Conservation Area Advisory Committee

Meeting Date : 6 August 2012

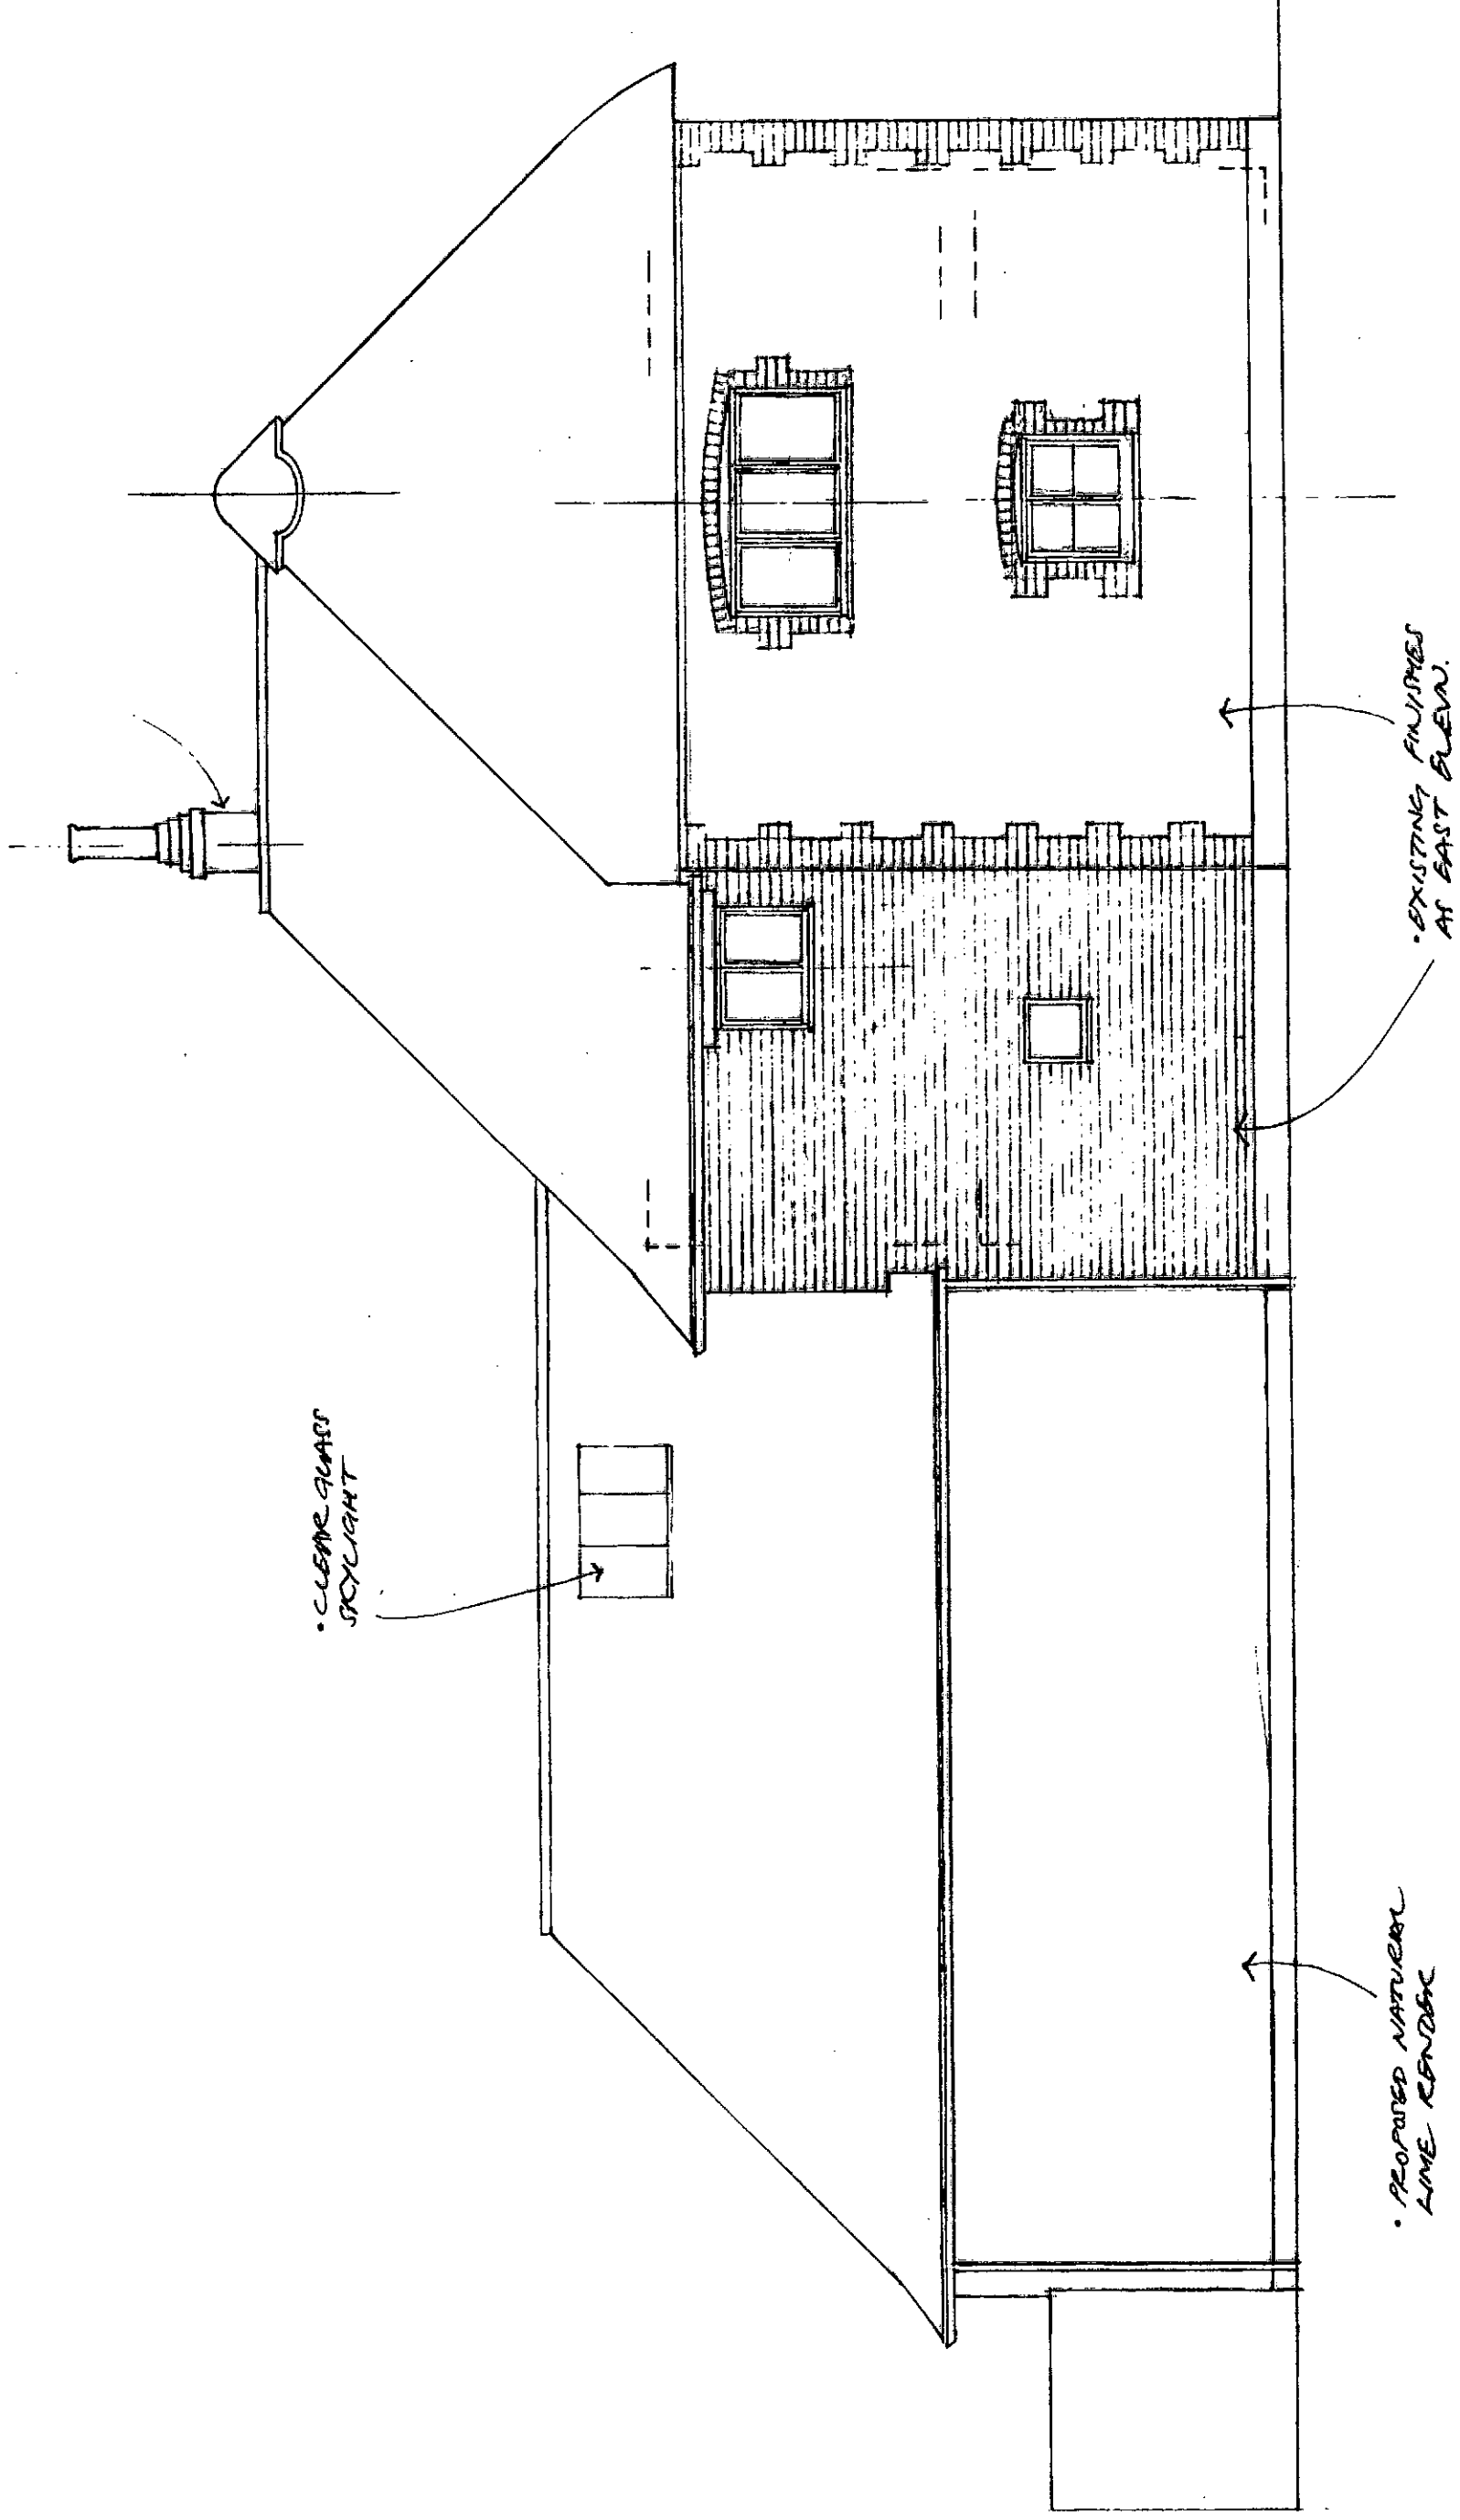
App No	Description/Address	Comment	Recommendation/Observation
BR/178/12/ SC	Construct a tiled pitched roof over the existing flat roof, construct a single storey extension and construct a single garage with a new access. Myrtle Cottage 67 Mead Lane Bognor Regis PO22 8AW	Objection	Out of scale with existing modest cottage and destroys the character of the LB and the Cons. Area.
BR/179/12/L SC	Application for Listed Building Consent to construct a tiled pitched roof over the existing flat roof, to construct a single storey extension and to construct a single garage with a new street access. Myrtle Cottage 67 Mead Lane Bognor Regis PO22 8AW
